M25 junction 28 improvement scheme

TR010029

9.103 Applicant's comments on Gardens of Peace Deadline 6 submission

May 2021

Drawing file: published-documents / TR010029-001054-PLAN 1 - PREM518-GEN-0000-0017 Rev H-Sht 2.PDF

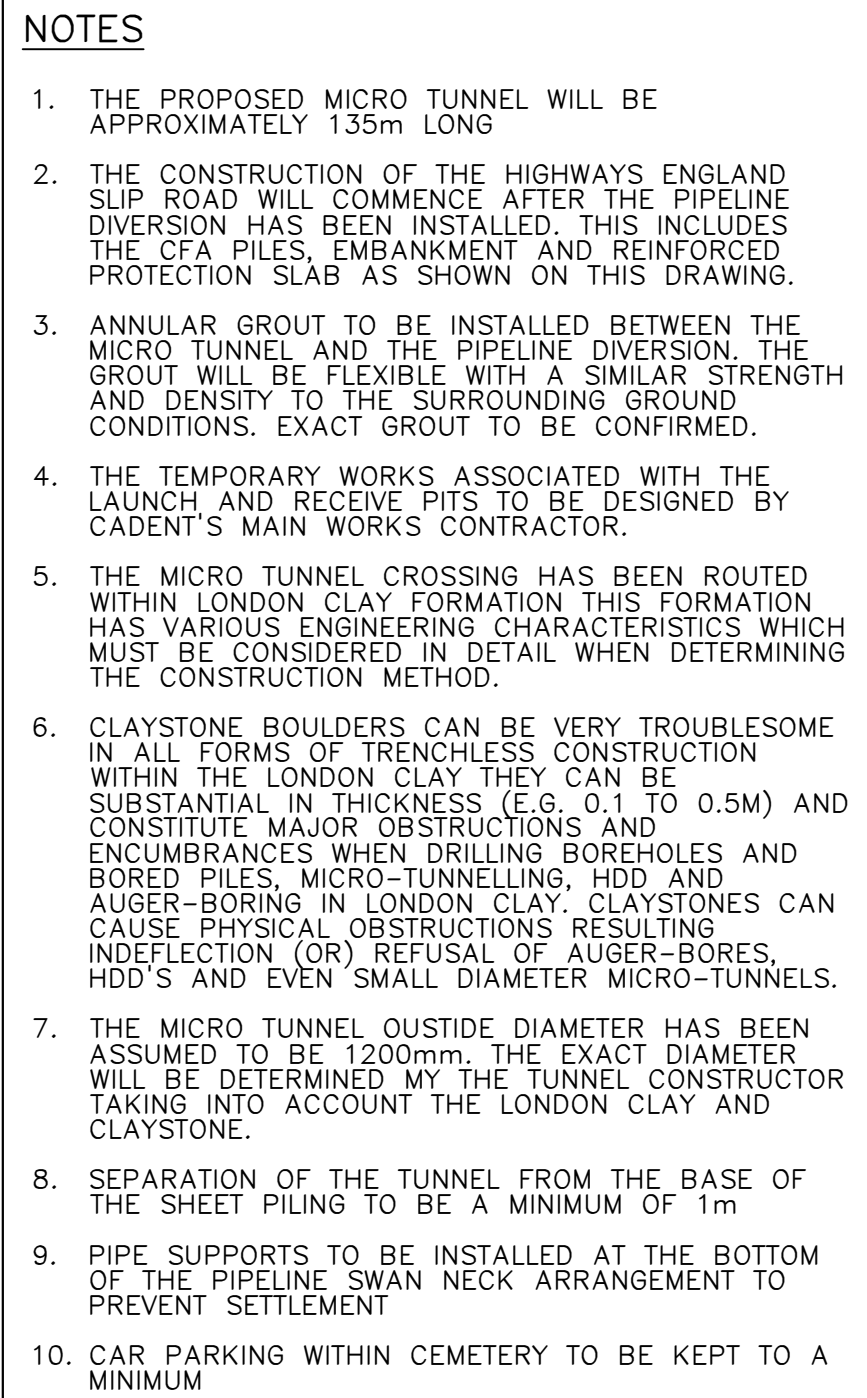
| Response reference: | Representation Issue | Highways England Response |
|---------------------|--|--|
| REP6-043-02 | <p>a) Loss of Service Entrance</p> <p>Whilst the loss of the service entrance will continue to be of concern to the daily running of the cemetery in terms of increased vehicular traffic using the main entrance, Gardens of Peace welcome the recent proposal of Cadent Gas (Drawing Reference PREM518-GEN-0000-0017) to allow access through Plot 1/8, via the service entrance, to collect soil from the soil storage area. This alleviates the concerns of heavy goods vehicles using the internal roads and bring rise to safety issues and damage to internal roads.</p> | <p>Highways England welcomes confirmation from the Trustees of Gardens of Peace (the "Trustees") that the recent proposal from Cadent (Drawing Reference PREM518-GEN-0000-0017) to allow access through Plot 1/8, via the service entrance, to collect soil from the soil storage area is accepted.</p> |
| REP6-043-03 | <p>b) Soil Storage</p> <p>As per the Applicant's response at Deadline 5, a revised soil storage site has been agreed with Cadent Gas, which will fall within the boundary of Plot 1/8. This alleviates the aesthetic and safety concerns with the original proposed soil storage location at the main entrance of the cemetery.</p> | <p>Highways England confirms that the location of the soil storage area which will fall within the boundary of Plot 1/8 (as shown on Drawing Reference PREM518-GEN-0000-0017) has been agreed by all parties.</p> |
